Rezoning Transportation Analysis

Petition Number: 2024-011

General Location Identifier: 02946195.

Date	Description
02-21-24	First Review (TM)
03-20-24	Second Review (TM)

Drawing Title: **Site Details**

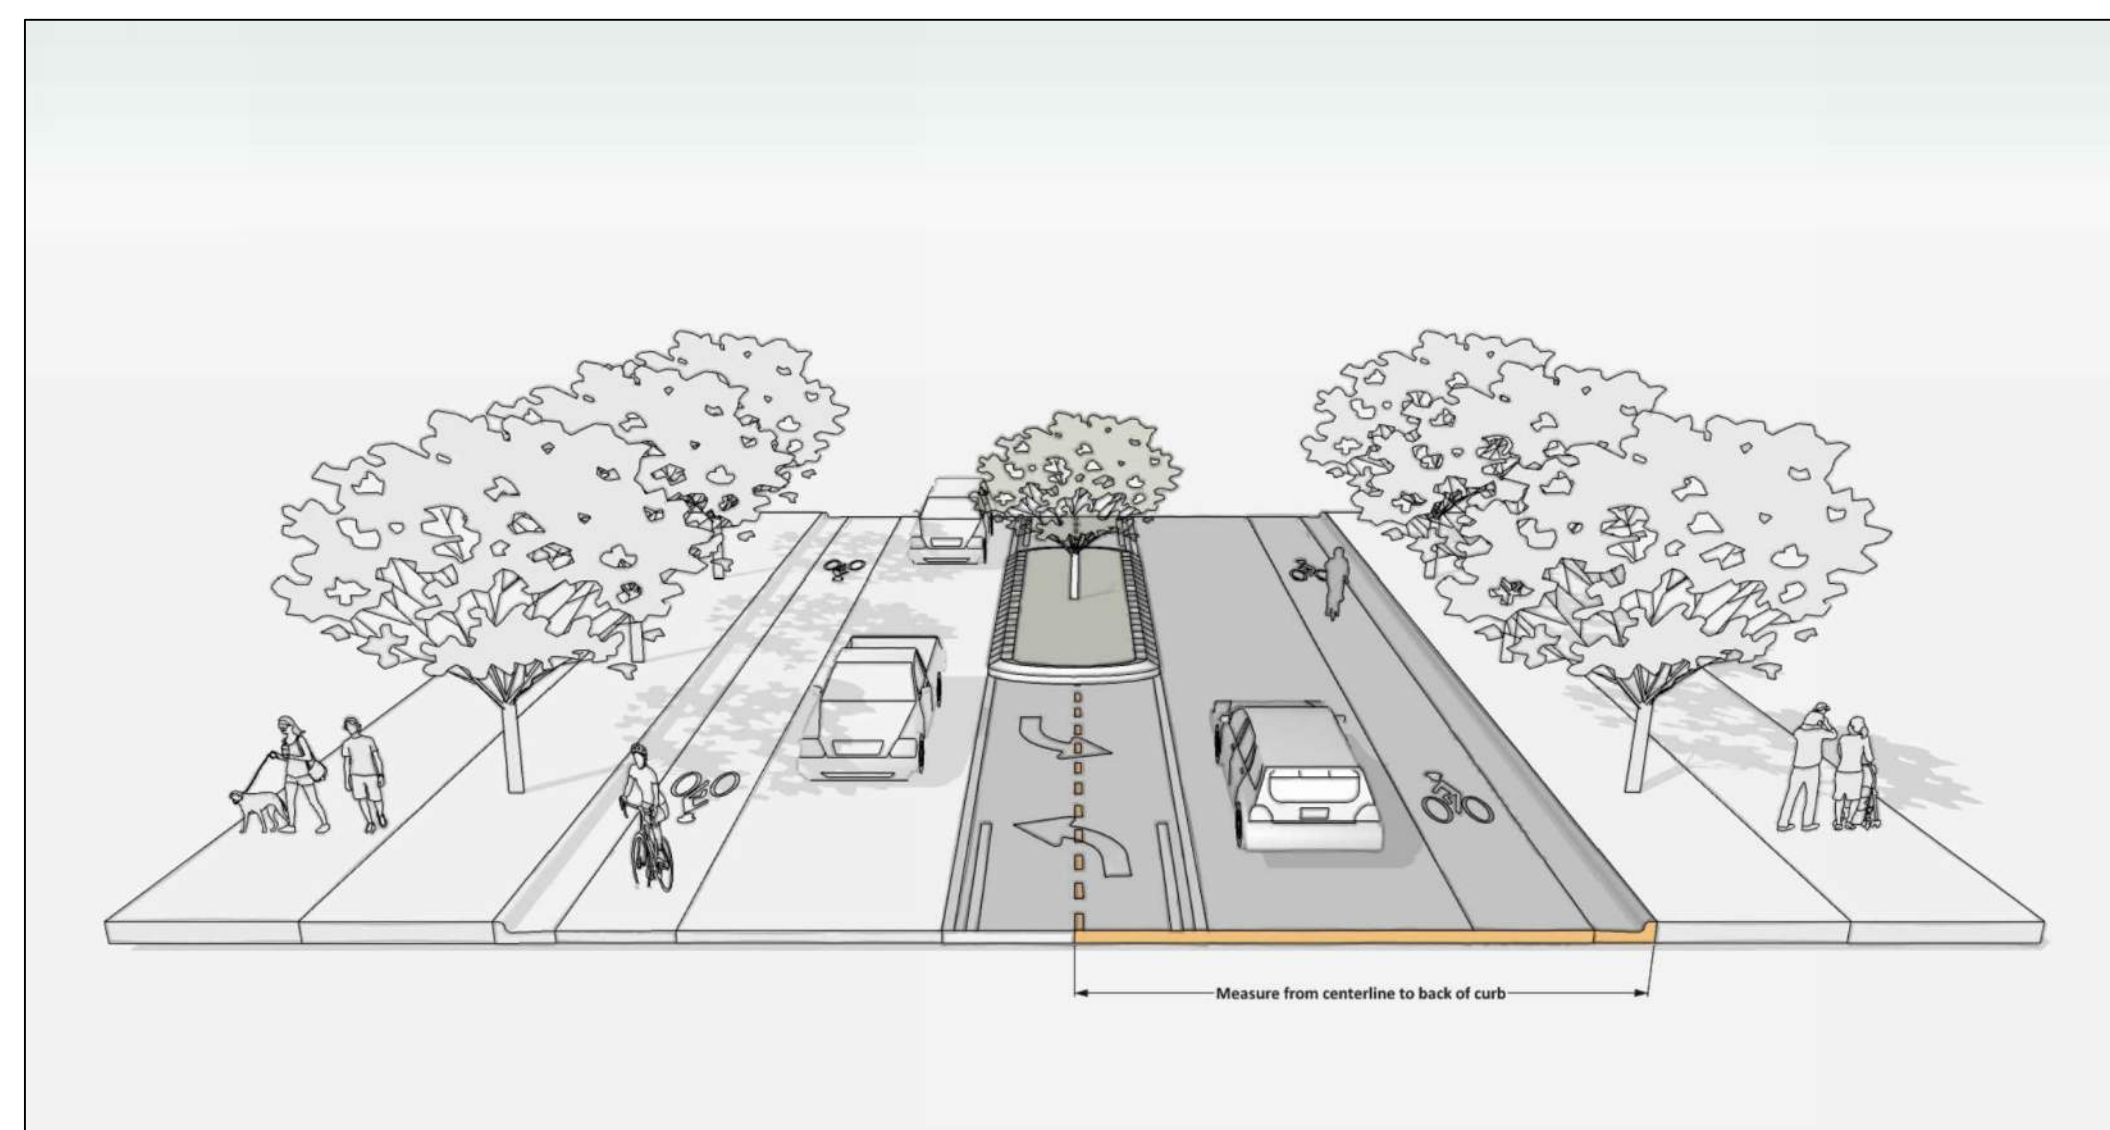
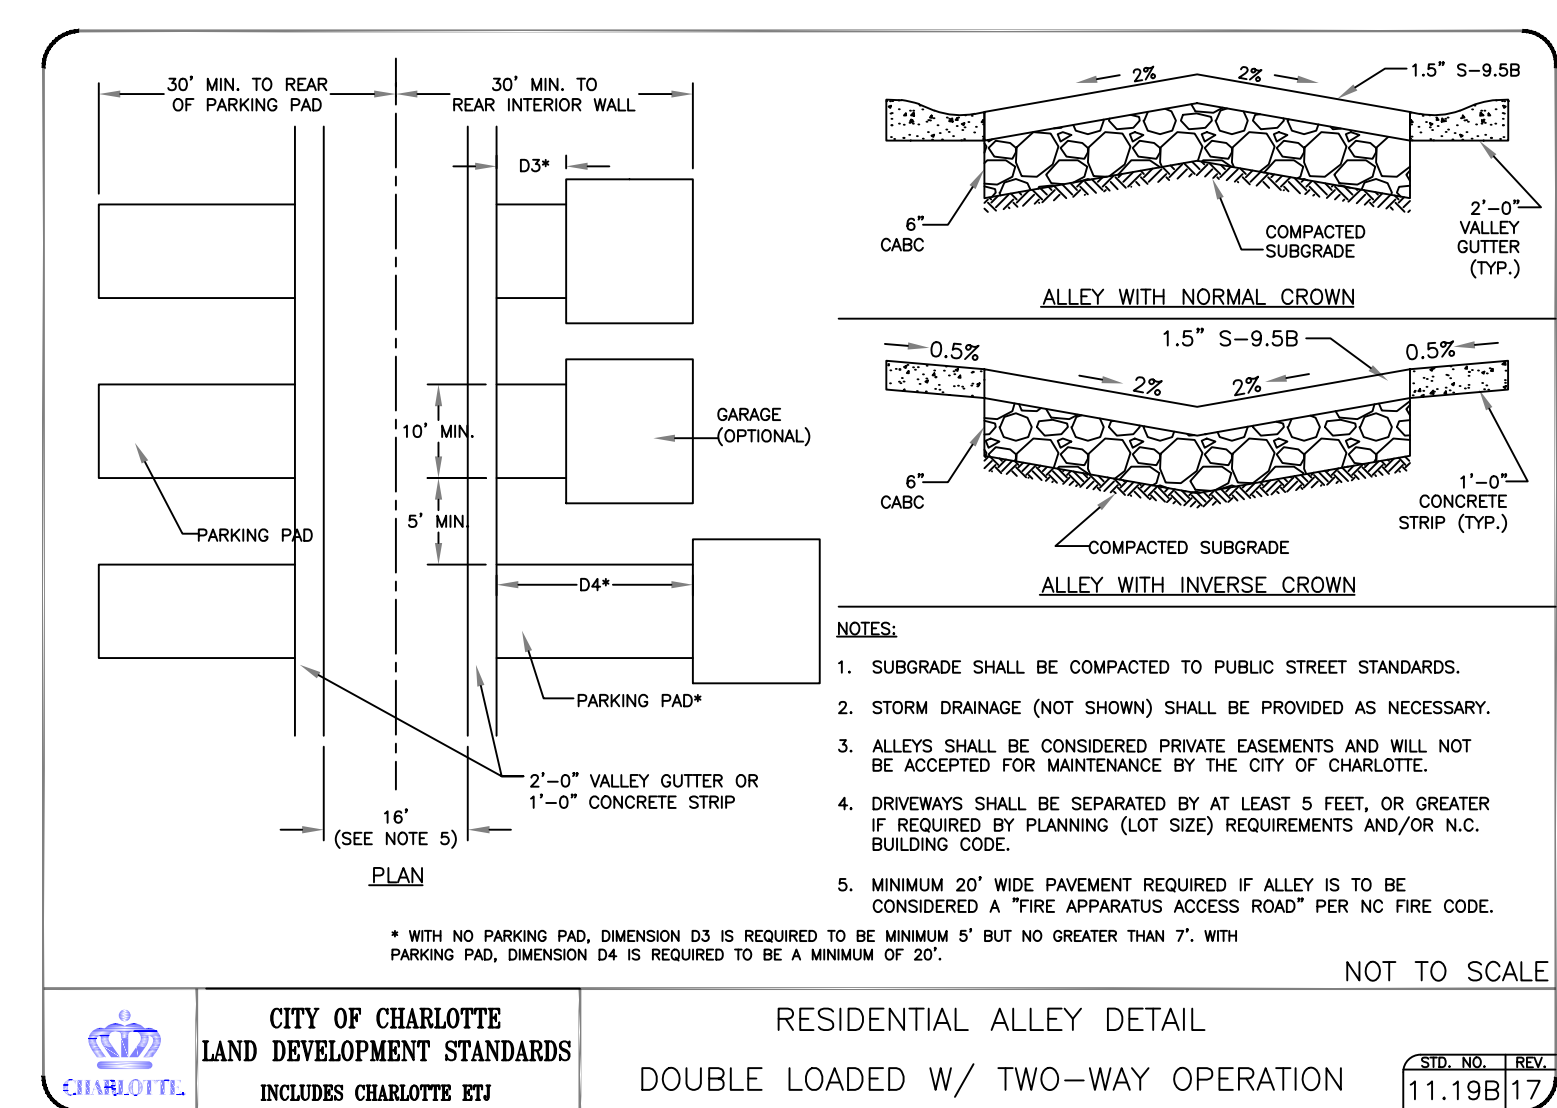
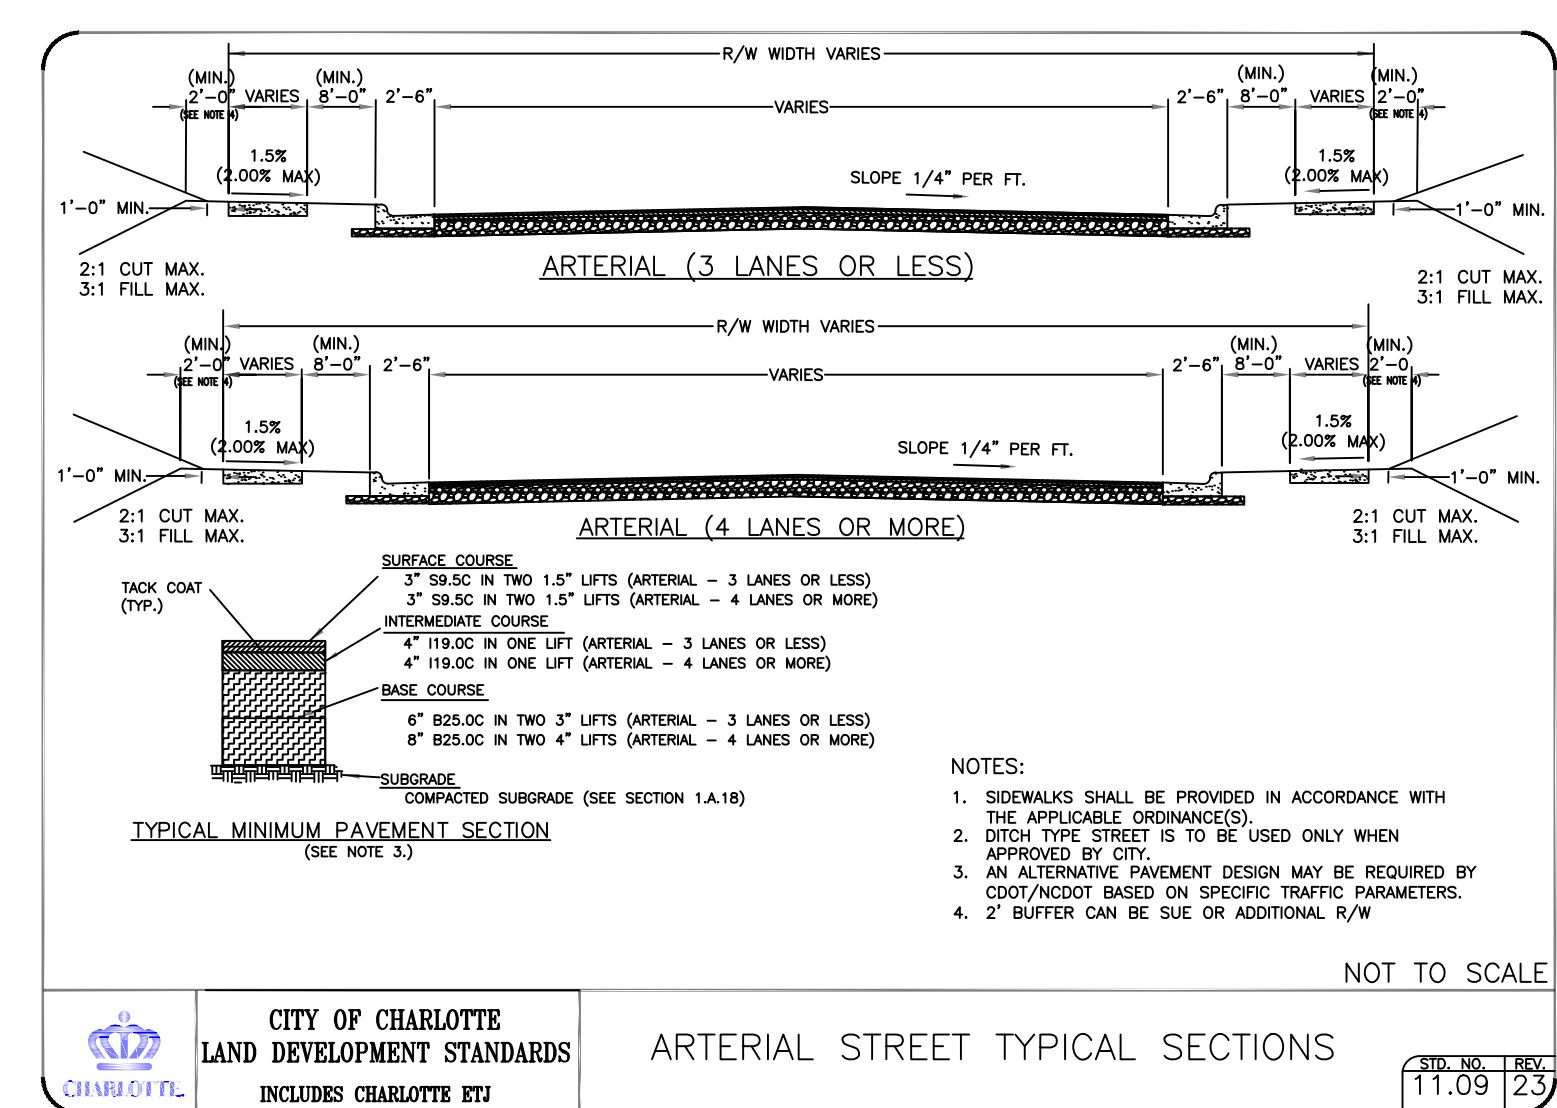
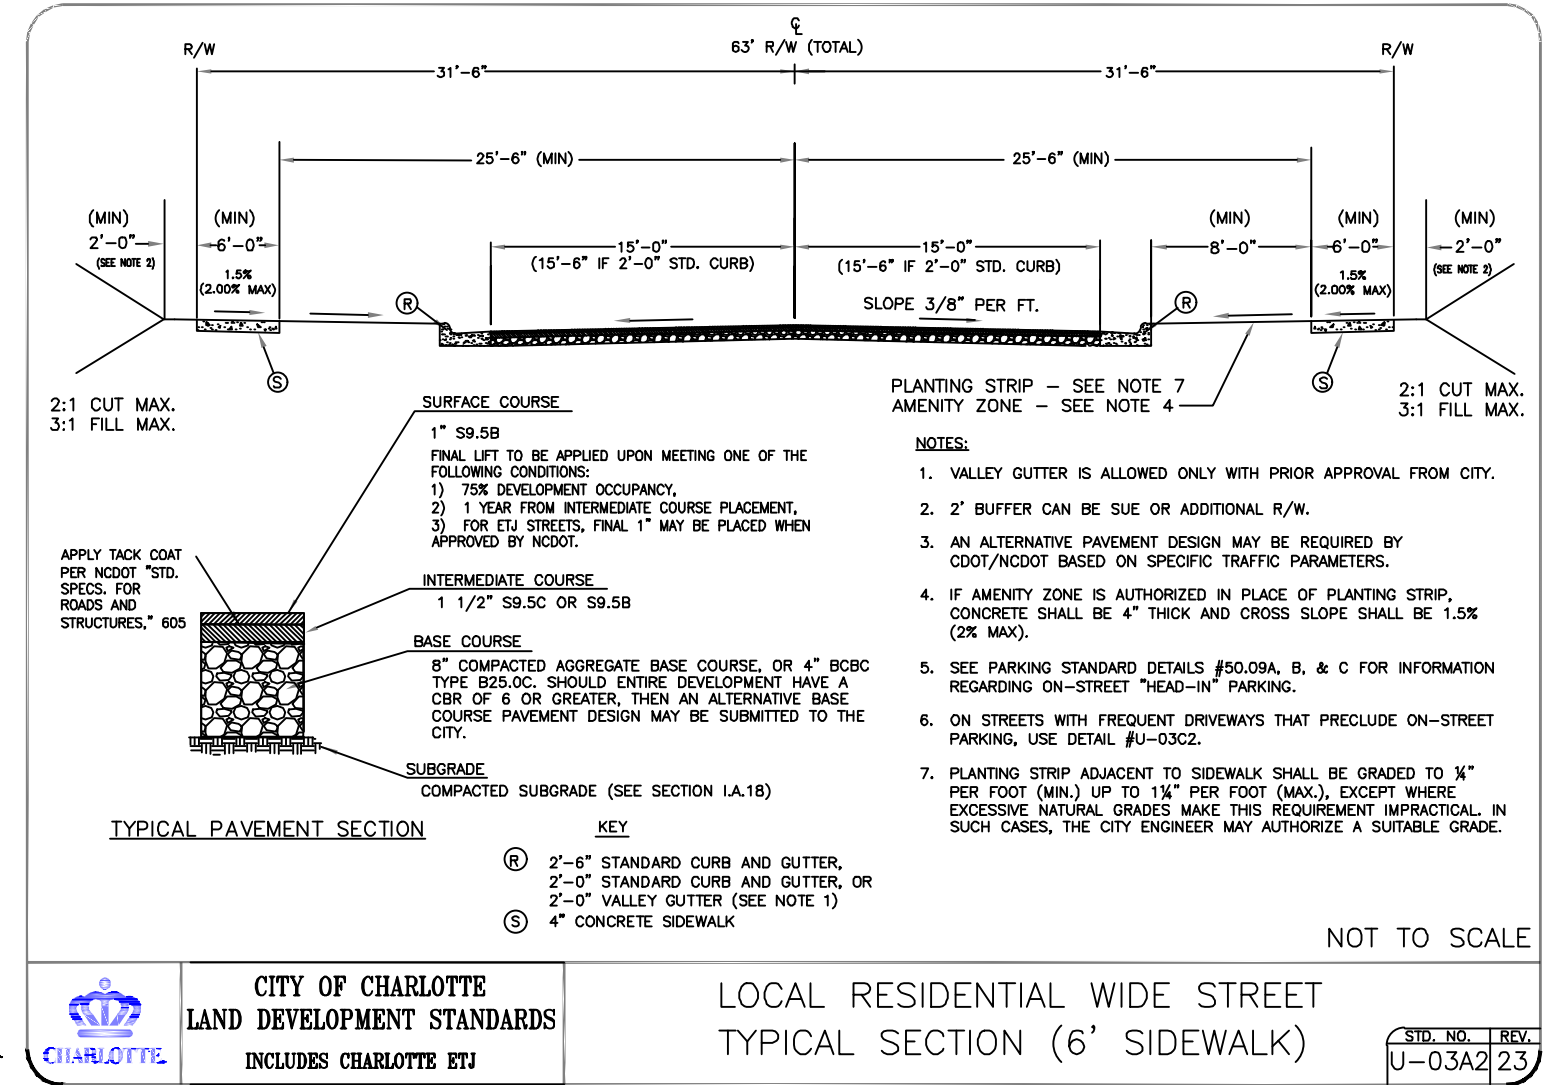
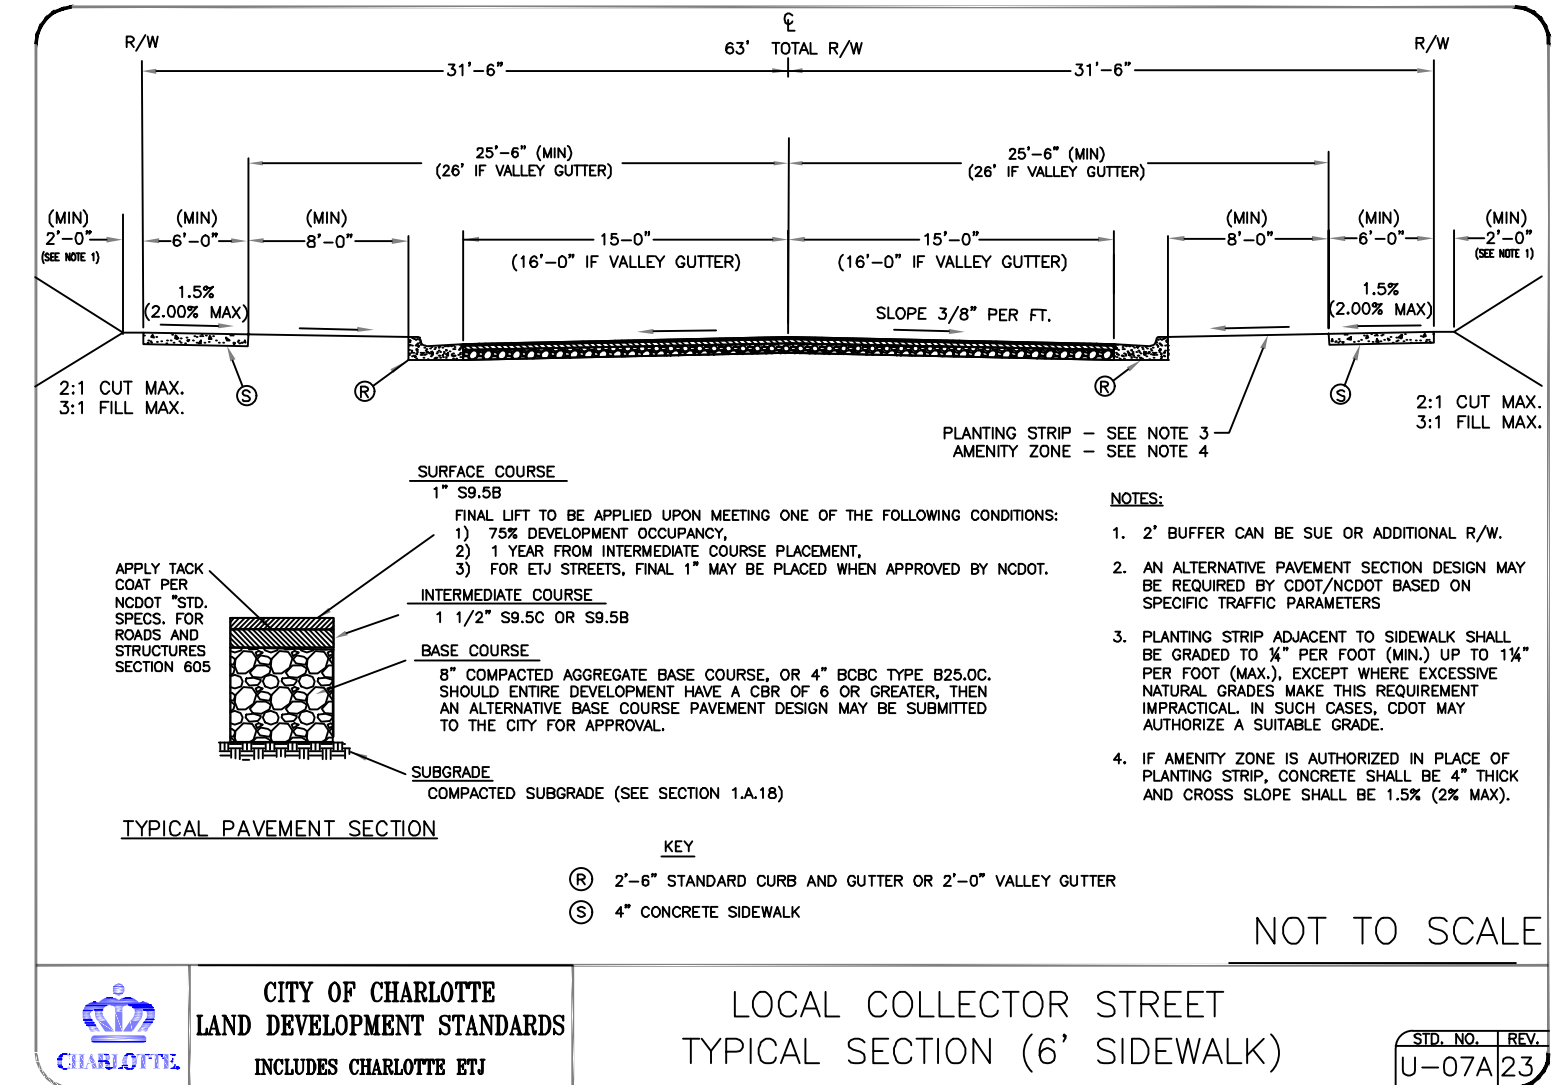
Label and dimension the curb and gutter from the centerline for each road on the site plan.

- ~~3. Revise site plan and conditional note(s) to commit to construct bicycle facilities by locating the curb and gutter 24' from the center line of Johnston Oehler Road in accordance with the council adopted Charlotte Streets Map.~~
4. Revise site plan and conditional notes to construct internal public roadways as Local Residential Wide roadway (CLDSM U-03, U-03A1, U-03B and U-03C1) in accordance with table 33-2 in chapter 33 of the UDO.
5. **Outstanding CDOT Issue from 02-21-24:** Revise site plan and conditional notes to construct 8-foot sidewalk on all internal public roadways per table 33-4 in chapter 33 of the UDO.

Clarifying Comment 03-20-24: An 8 foot planting strip and 8 foot sidewalk are required in N-2 per UDO chapter 33. Revise site plan to commit to installing an 8-foot sidewalk throughout the site on all public roadways.
